**Approval of details reserved by condition imposed under ref APP/C3810/W/16/3155330 (AL/8/16/OUT)
relating to Condition Nos 11 - visibility splay, 12 - fire hydrant, 13 - foul drainage, 14 - surface water
drainage and 18 - external lighting**

Land To South Of Barnside Hook Lane Aldingbourne PO20 3TE

Decision:

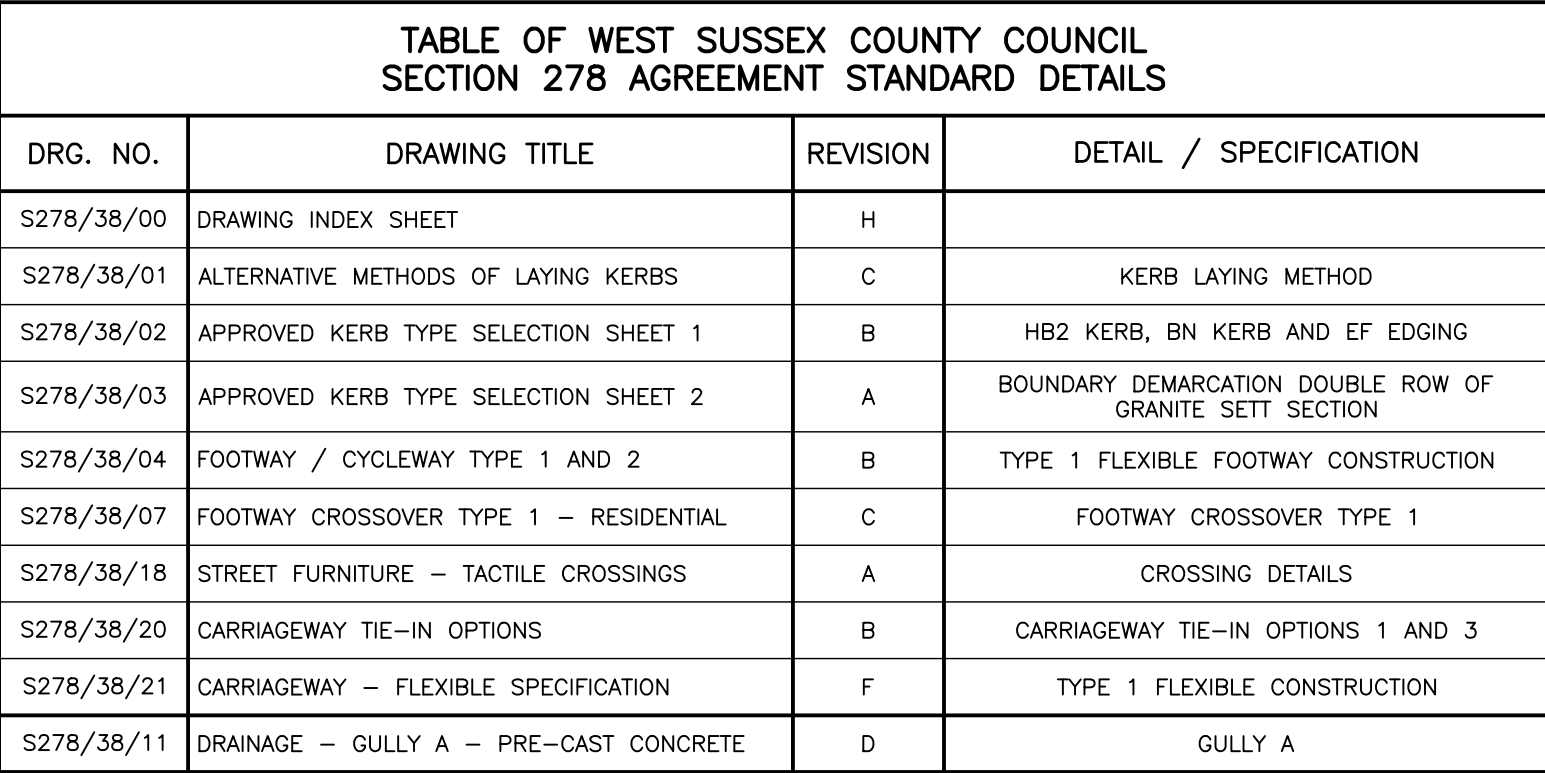
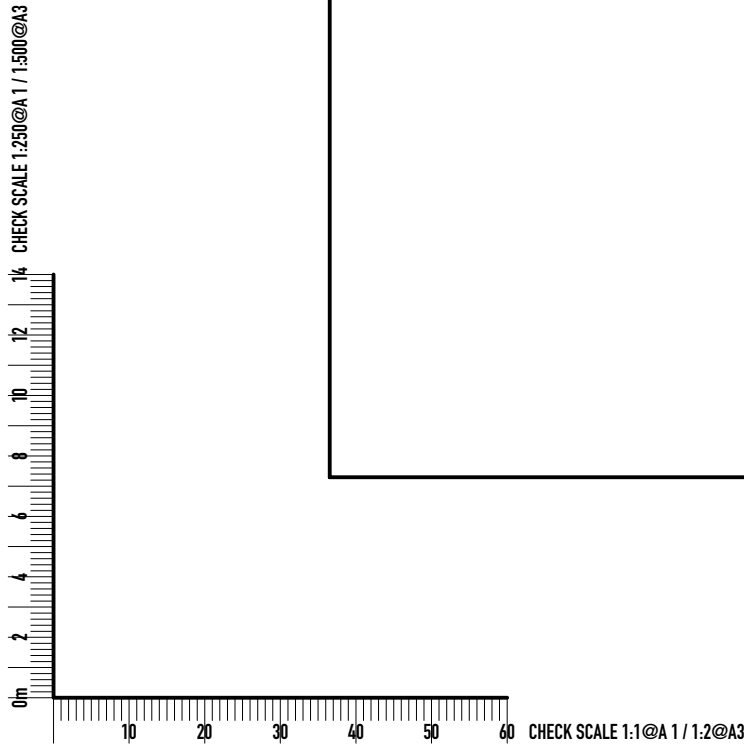
Arun District Council have decided to **REFUSE details reserved by condition for the following reasons:**
Council Drainage Engineers have objected to the discharge of this condition on the grounds that it unclear as to whether the layout drawing provided is as constructed or as proposed and in addition, there is insufficient information to satisfy the Council that the drainage scheme is fit for purpose (please

refer to the 16 points in the consultation response dated 01/05/20 which was duly forwarded to the applicant). As such, the condition cannot be discharged and you will need to make a revised submission.
